Land fronting, Turnbull Road, Fradley, Lichfield

**Application by Massey Limited for the variation of Condition 2 of planning permission
REF: 18/O1693/FUL**

This Application is for variation of Condition 2 of planning permission 18/O169/FUL, 28th October 2020. That planning permission is for the erection of 8no. dwellings and associated works.

PLANNING | HOUSE TYPE 1

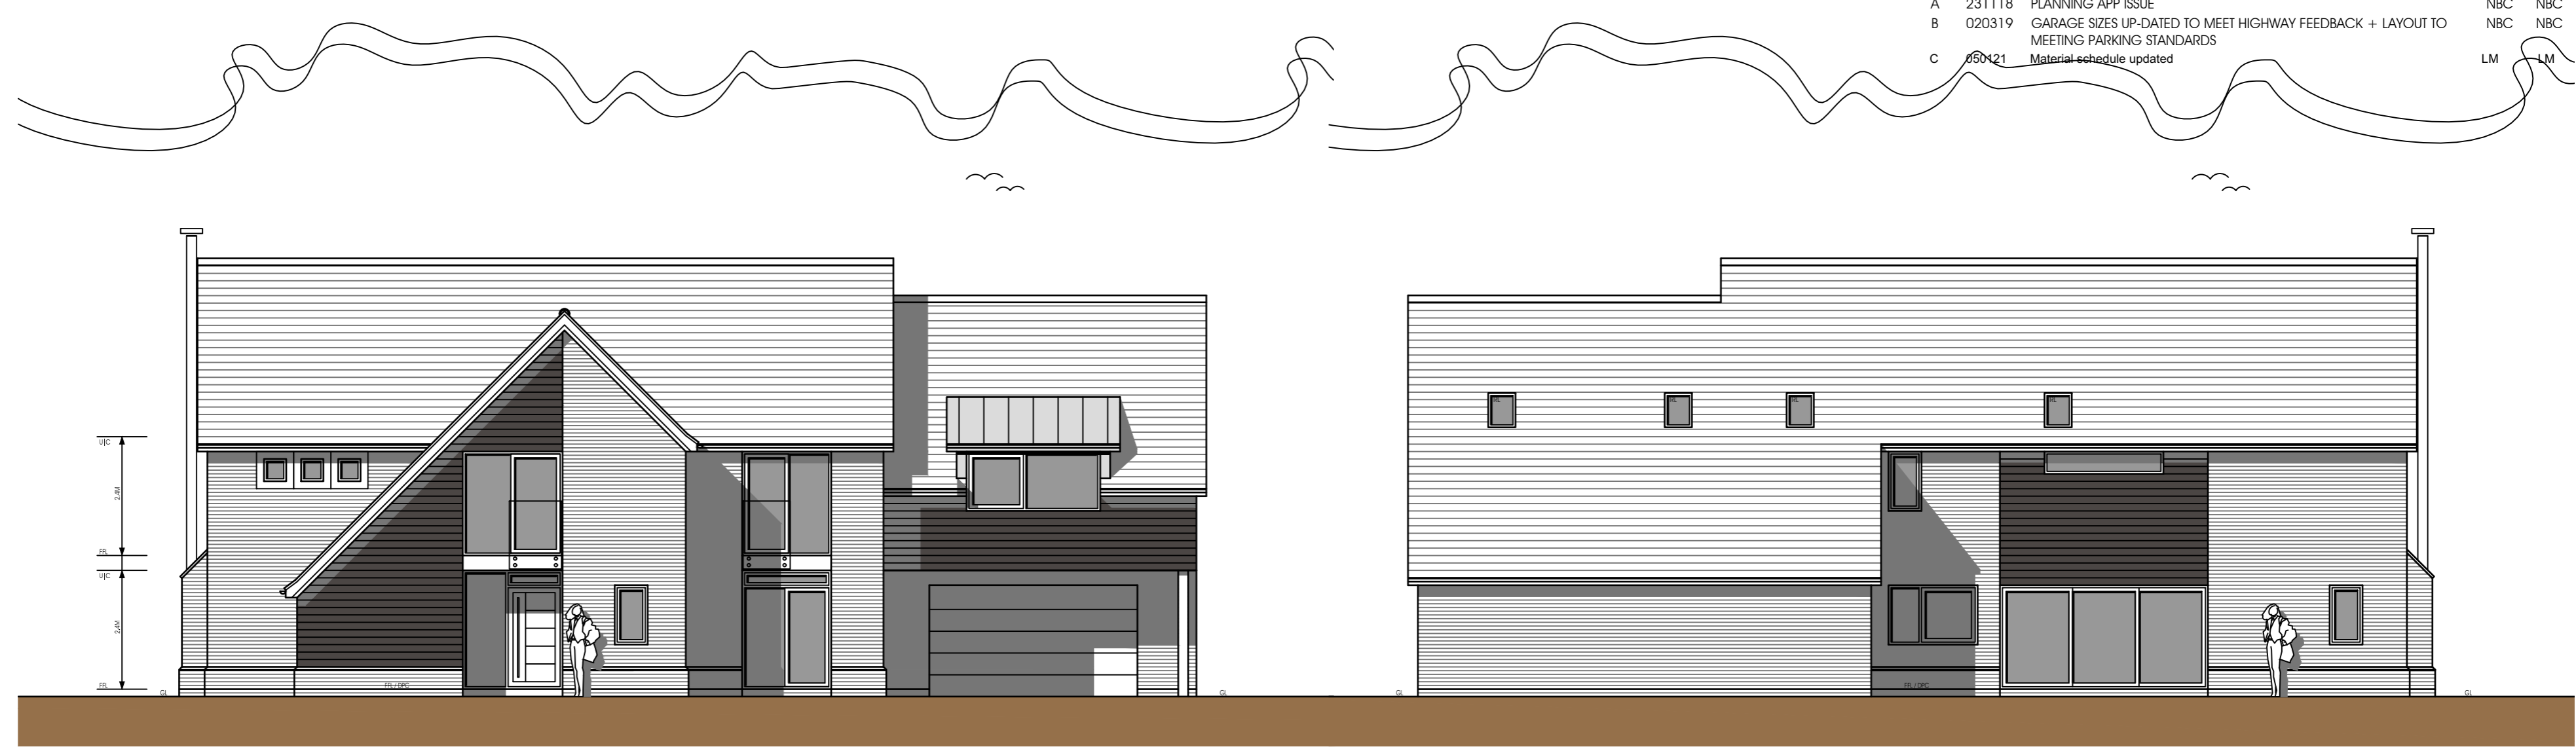
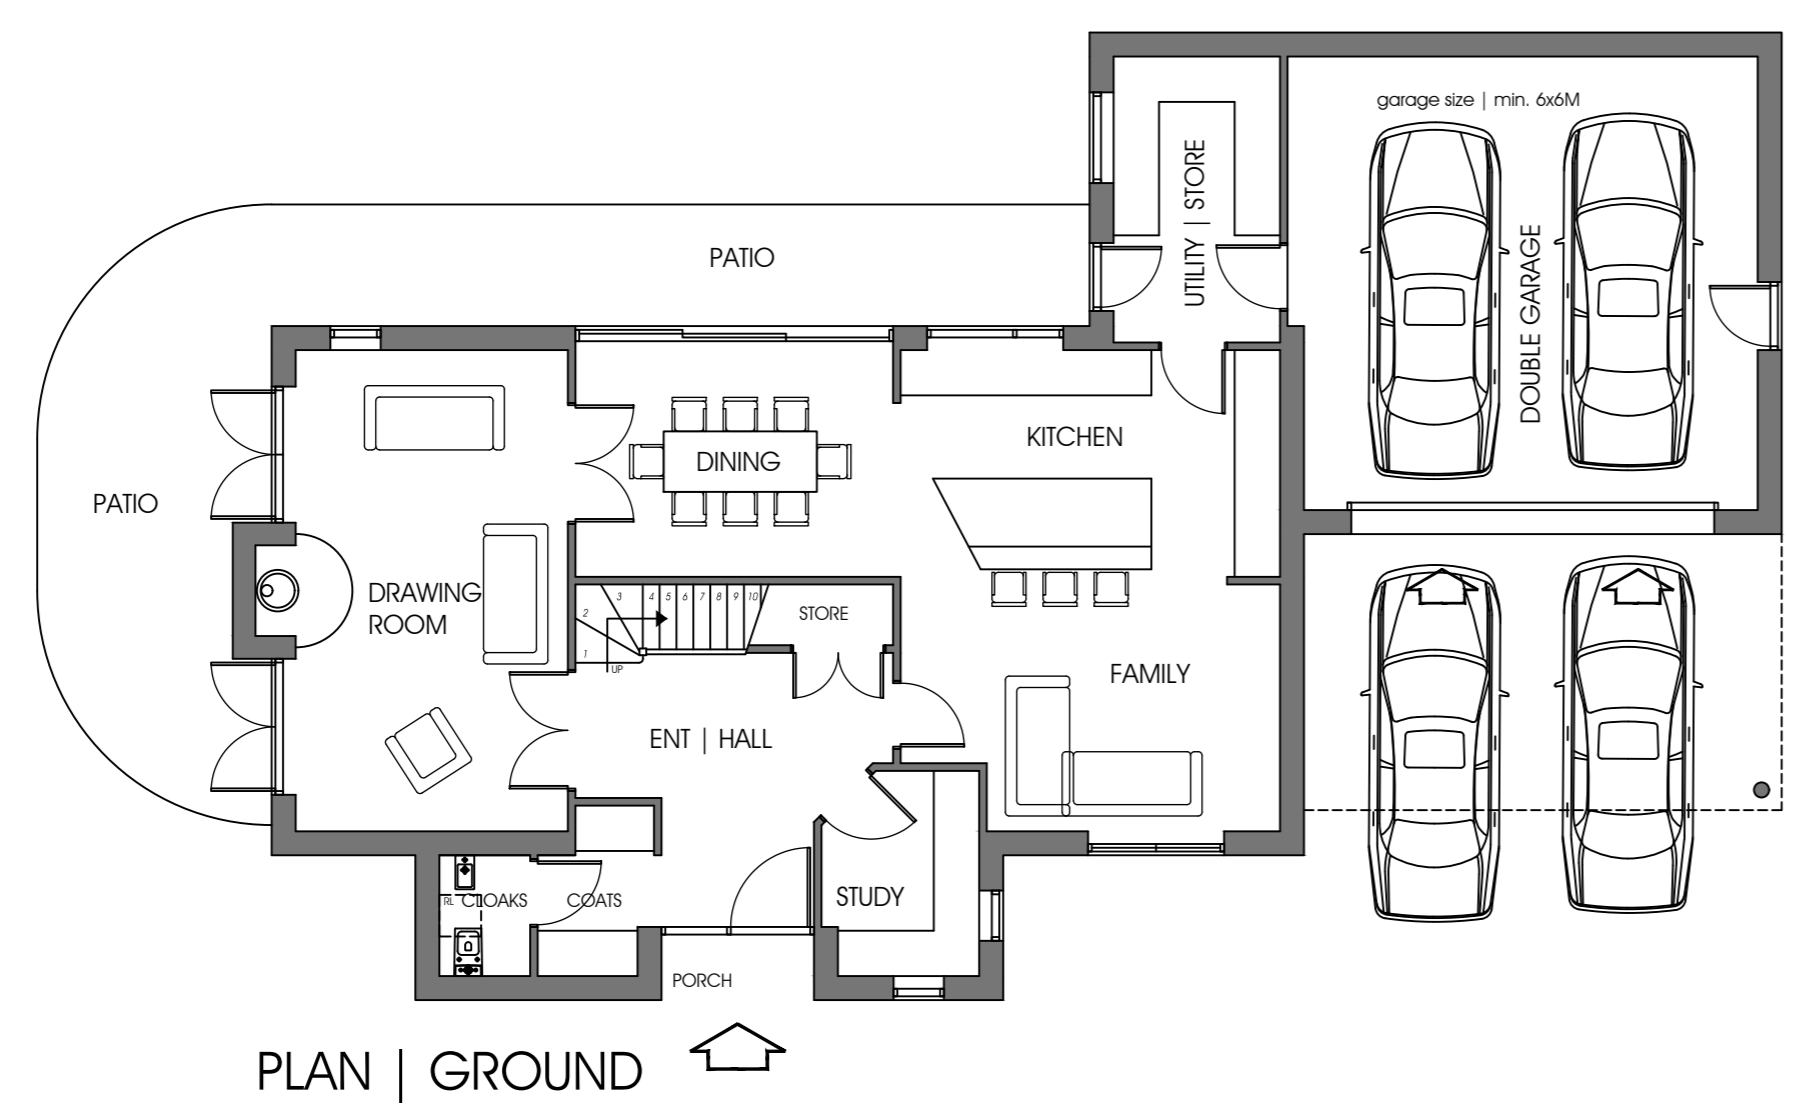
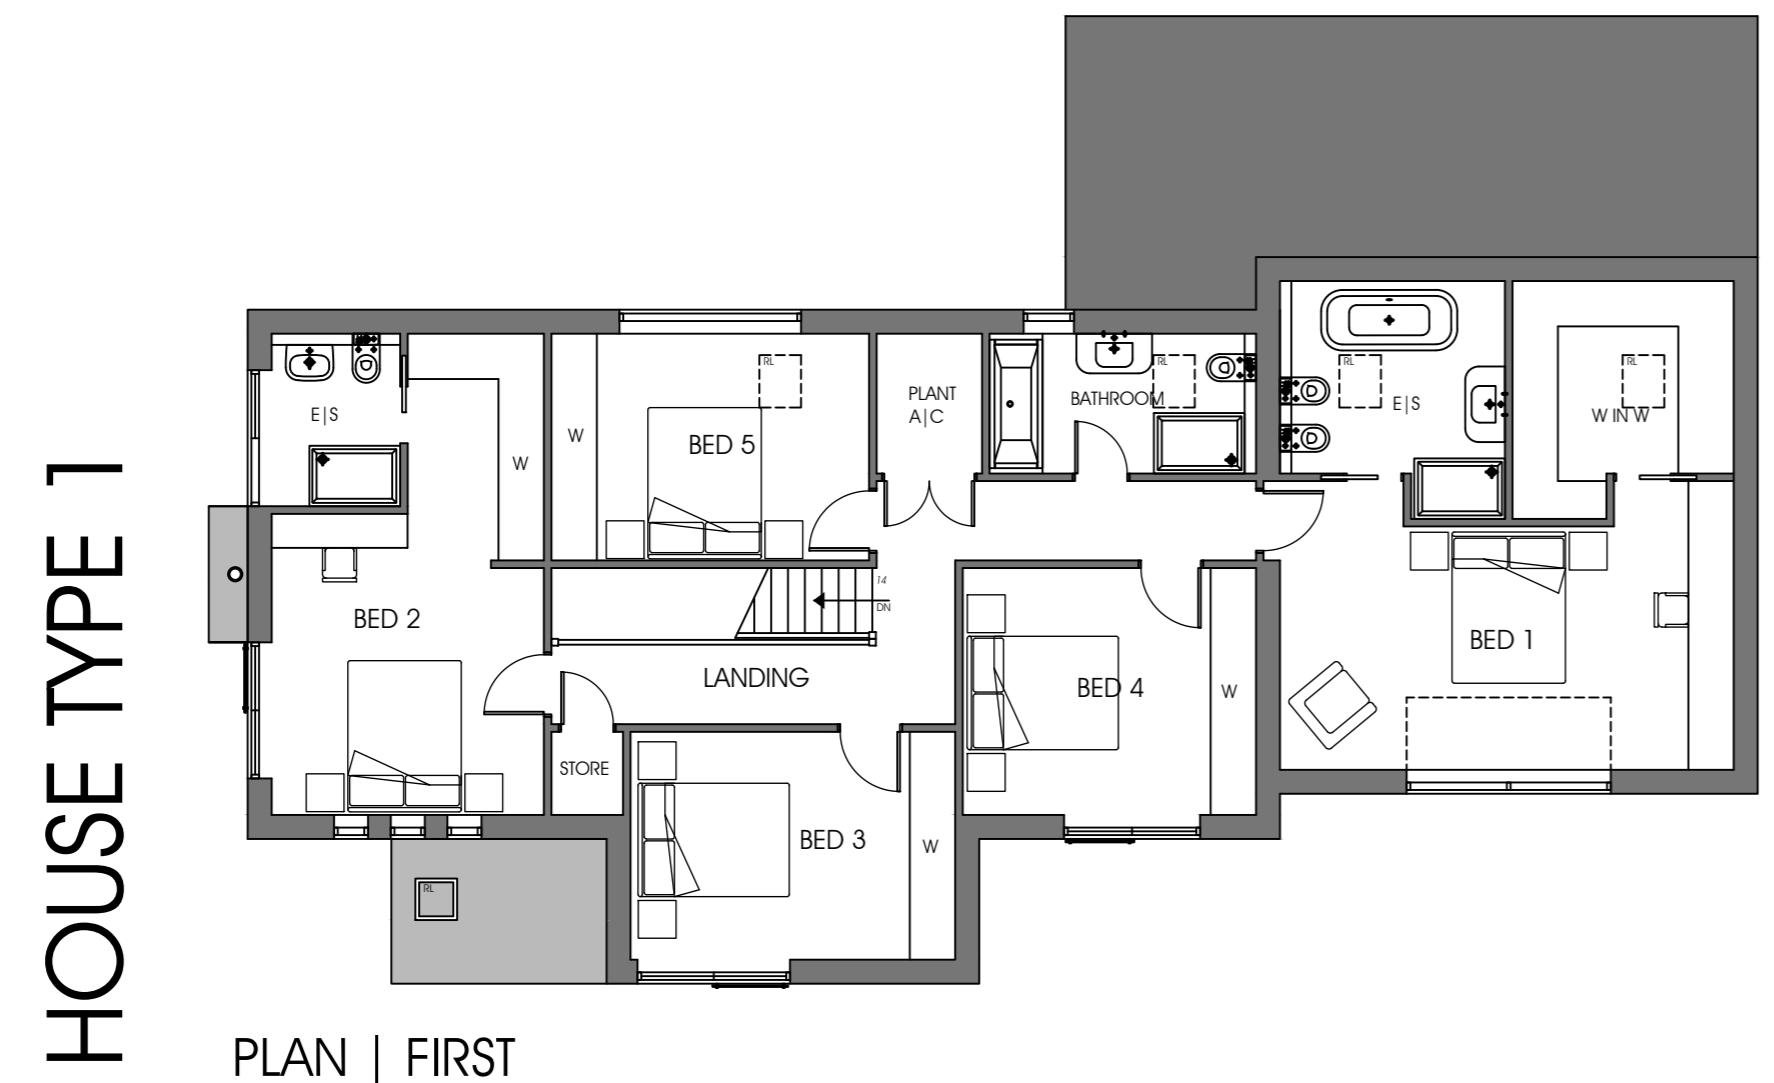
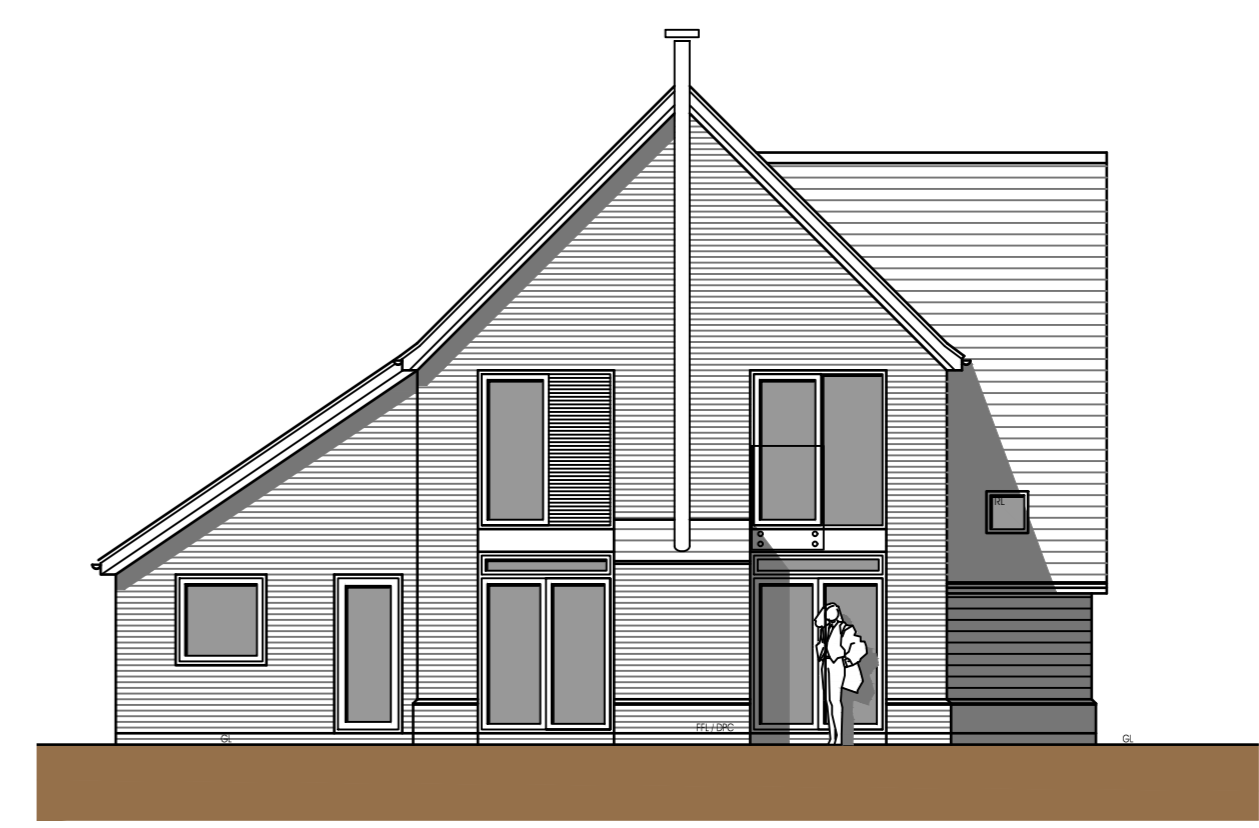
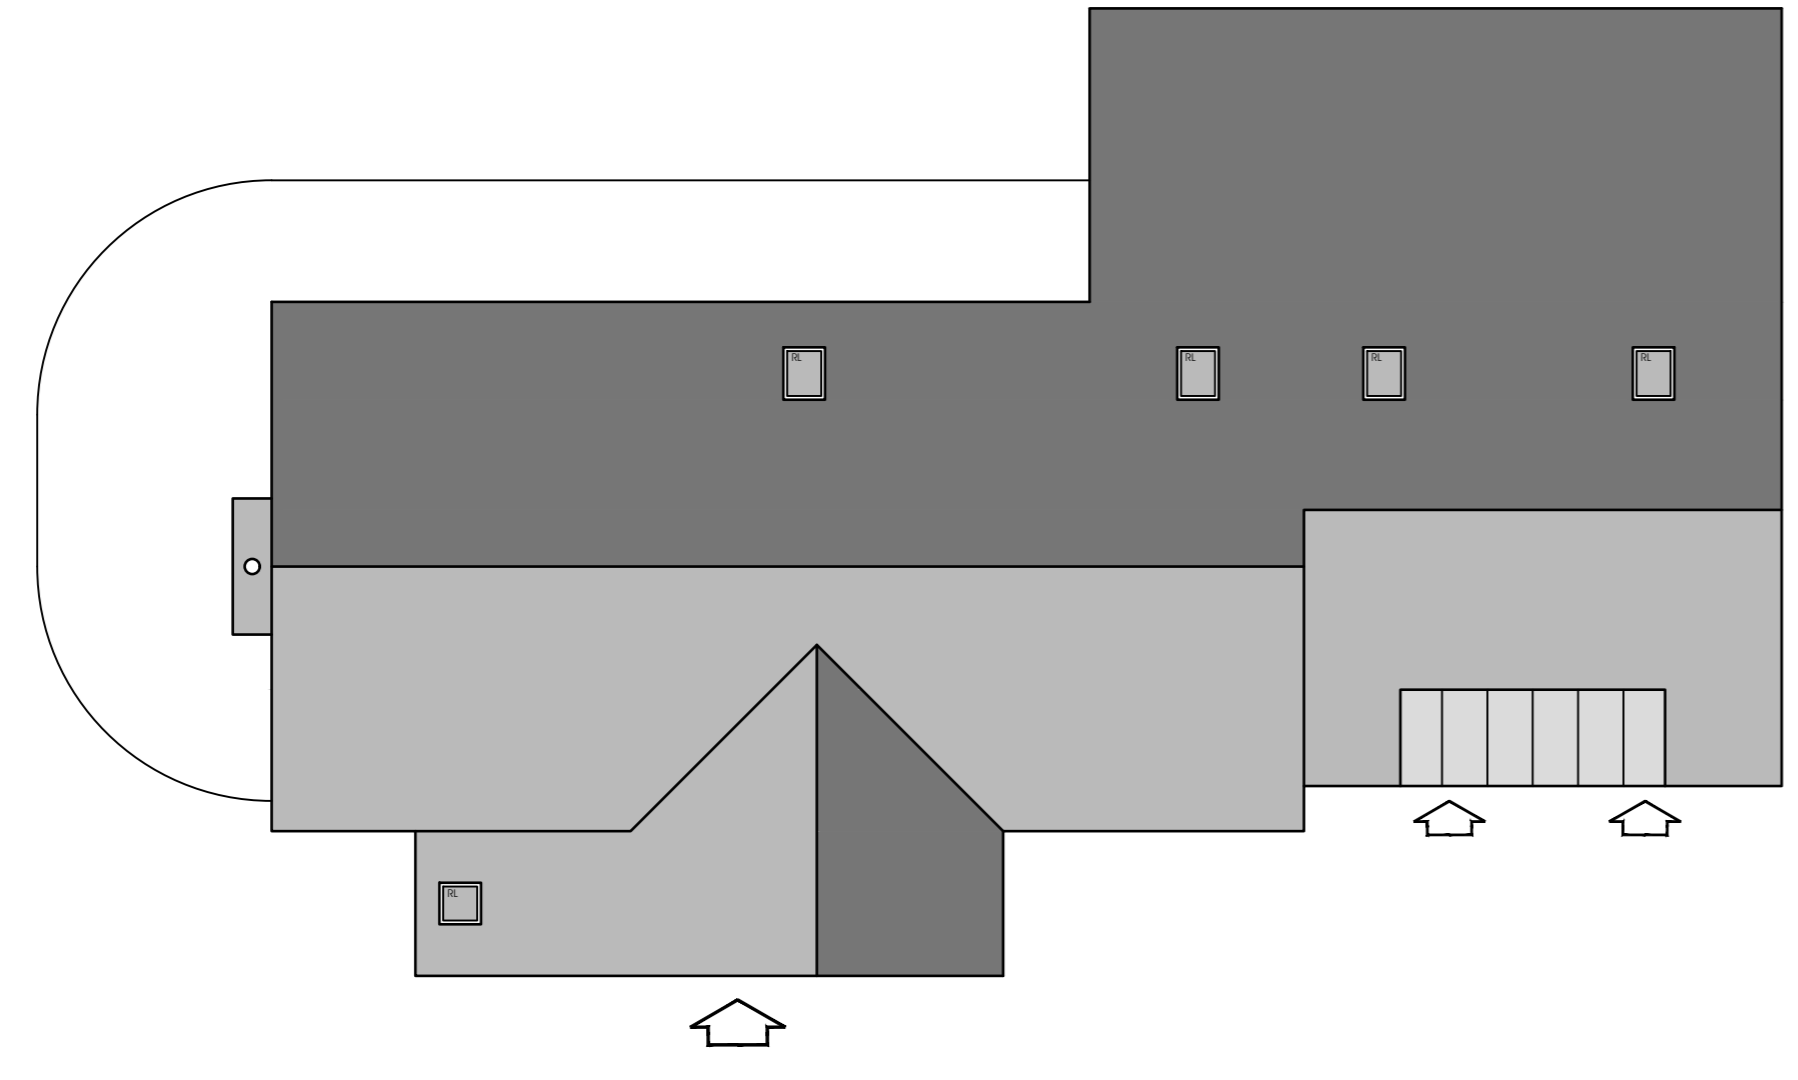
Proposed minor alterations to external materials, namely the roof covering and window frames are outlined below.

Roof covering - Marley Ferndale tiles do not exist. Marley Edgemere tiles are a slate-style tile, in keeping with the consented design.

Windows and doors - Flush casement anthracite grey window frames proposed in lieu of PPC black frames.
